HWSFAC Hillingdon Water Sports Facility and Activity Centre

1329-HAV-XX-XX-RP-A-S2 -
0019_Planning Statement:

Response to Planning Application Urban
Design Officer Comments

Date: 09.02.26

1 Safety Zone - Section AA

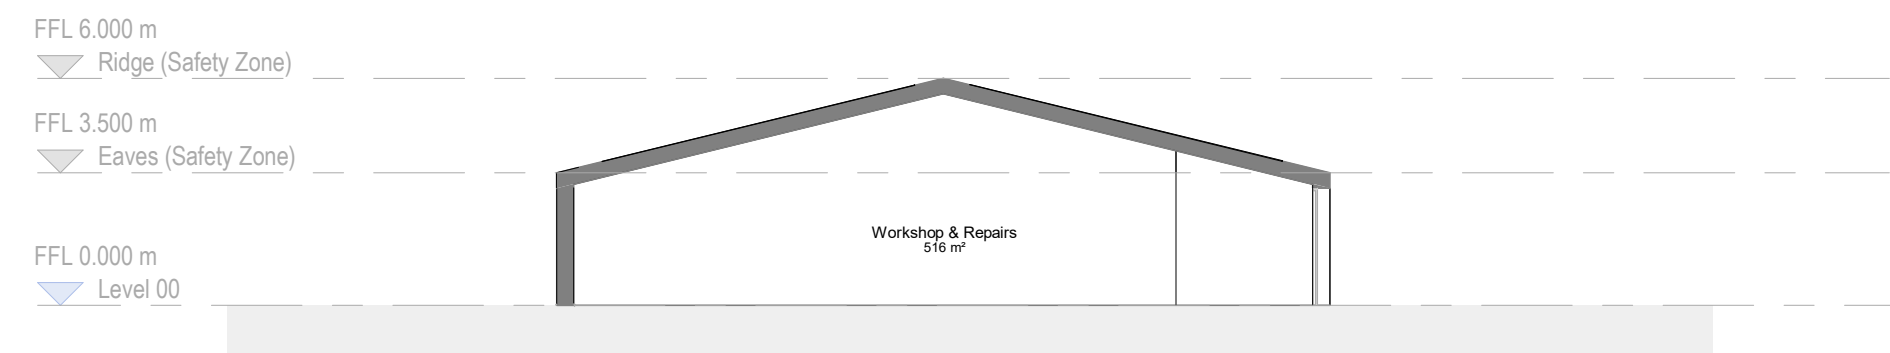
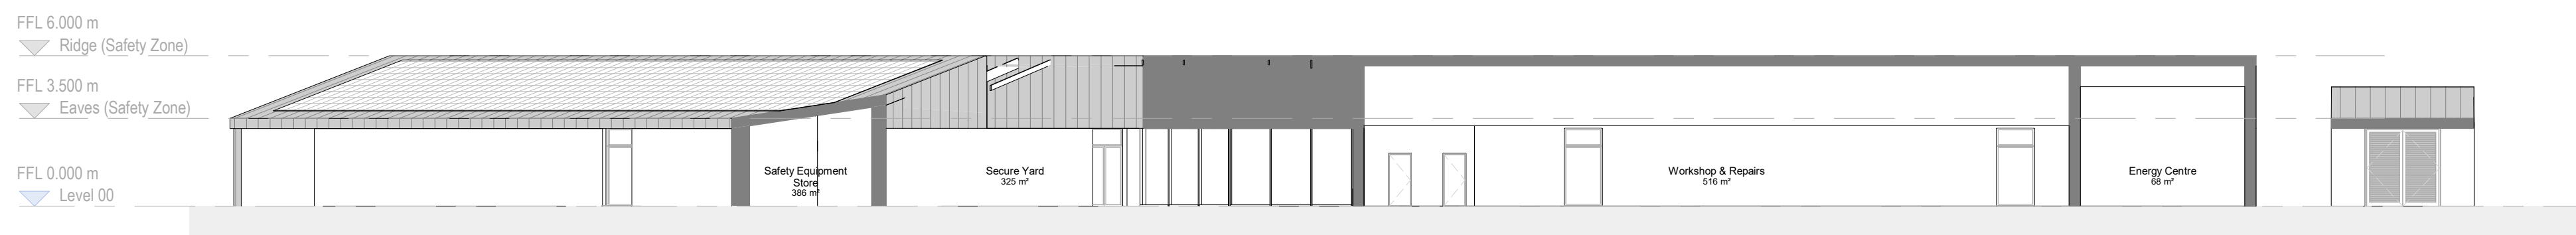
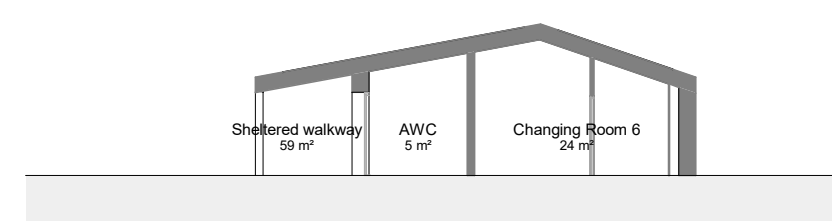
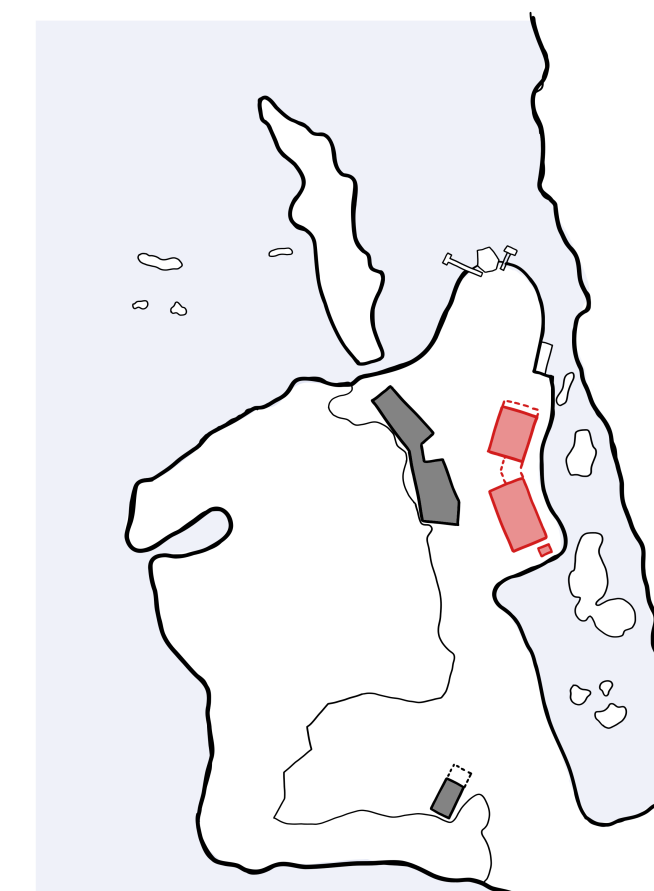
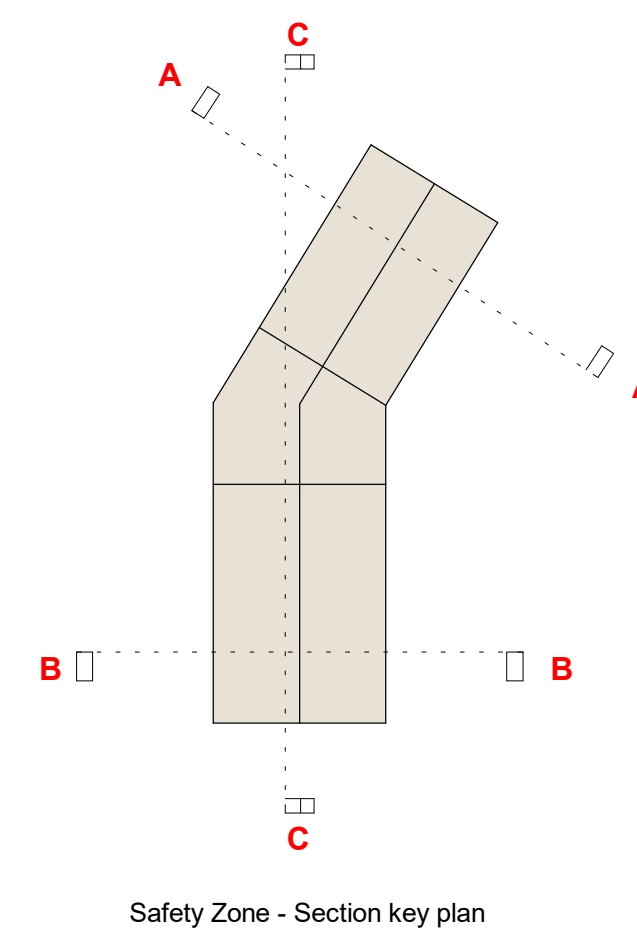
<p>Further the exposed structure appears awkward adjacent to the solidity of the flint. More explanation is required for this element, to explain the roof material and structure material.</p>	<p>The central yard of the Safety Zone is partially covered to provide shelter while maintaining the open, light space needed for boat maintenance and repair. The exposed structure where the roof is cut out provides a deliberate contrast to the flint walls. In combination with the gates, this helps break up the building mass, creating the appearance of two distinct buildings and reducing the visual impact of the roof form, while enhancing permeability and visual interest.</p> <p>The ability to maintain and repair boats on site is essential to the operational and financial viability of the facility, and the partially covered yard is a key enabler of this activity.</p>
<p>Anglers Hut/Camping Zone/BSC Store</p> <p>Clarification is also sought on whether the BSC store remains part of the proposal.</p>	<p>All storage for the BSC will be accommodated within the proposed Safety Equipment Store located in the Safety Zone. No separate BSC store is proposed.</p>

4 Camp Zone - Section AA

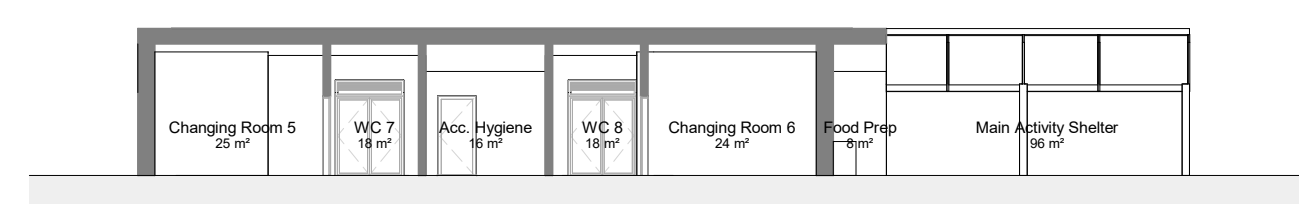
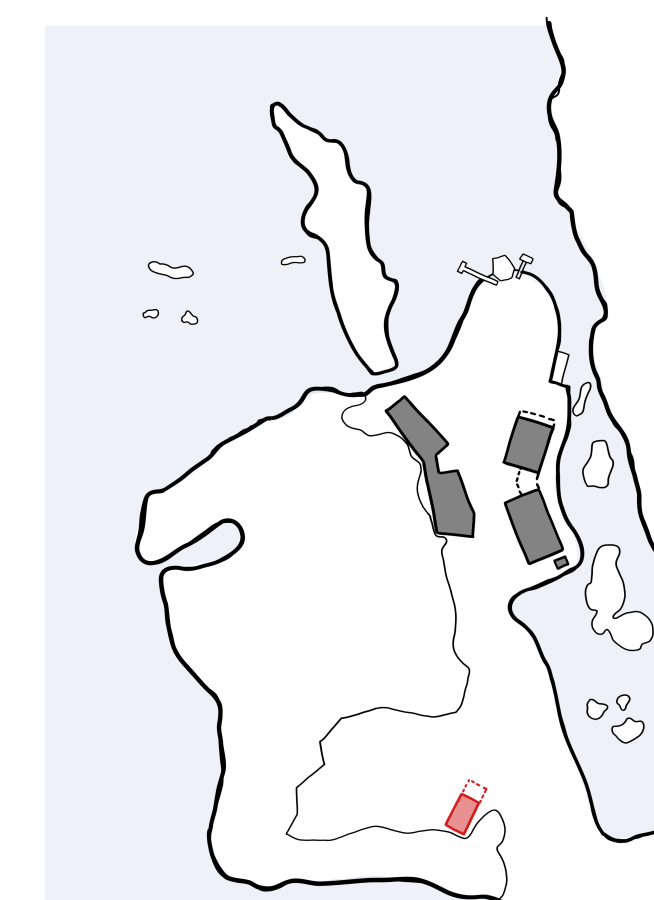
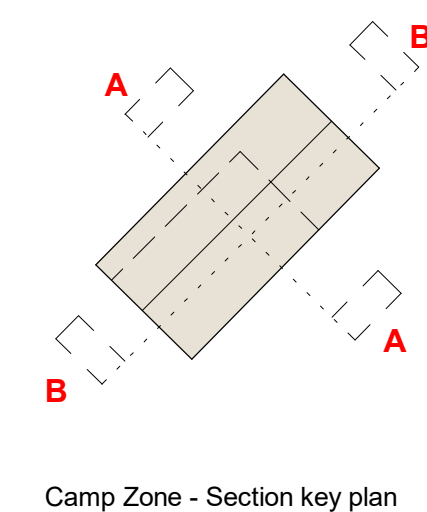
Whole Site (m ²)	Peninsula (m ²)	Building footprint	3077	3054	Area	783903	62818	Area that is building (%)	0.39	4.9
	Whole Site (m ²)	Peninsula (m ²)											
Building footprint	3077	3054											
Area	783903	62818											
Area that is building (%)	0.39	4.9											
<p>There remains a concern that the Camping Zone building is excessively large, with a covered roof area that would be better served by a seasonal covering, such as awnings.</p>	<p>The Camping Zone building has been amended to reduce its overall footprint and massing. The footprint has decreased from 224sqm to 171sqm,</p>

<p>This approach would reduce the building’s footprint and massing, and would also help prevent birds from nesting in the roof rafters, which could render the building unusable.</p> <p>Additionally, to better integrate the structure with its surroundings and further minimise its mass, a flat green roof would be a more suitable option.</p>	<p>with the eaves lowered from 3m to 2.6m and the ridge reduced from 5m to 4m.</p> <p>In response to previous feedback, the design has been revised so that only the changing block has a permanent roof. The activity shelter will comprise an open structure capable of being seasonally covered with tensile material, reducing the extent of permanent built form.</p> <p>Whilst a flat roof has been considered, a pitched roof is more consistent with the simple rural shed typology of the surrounding context and therefore integrates more appropriately with the landscape. The form also allows space for services and effective rainwater runoff.</p> <p>The provision of sheltered, adaptable space is essential to support inclusive use of the site, particularly for participants with disabilities or sensory needs, enabling safe and extended use in varying weather conditions and ensuring compliance with the Equality Act.</p> <p>Overall, the revisions significantly reduce built mass while maintaining the functional and accessibility requirements of the facility.</p>
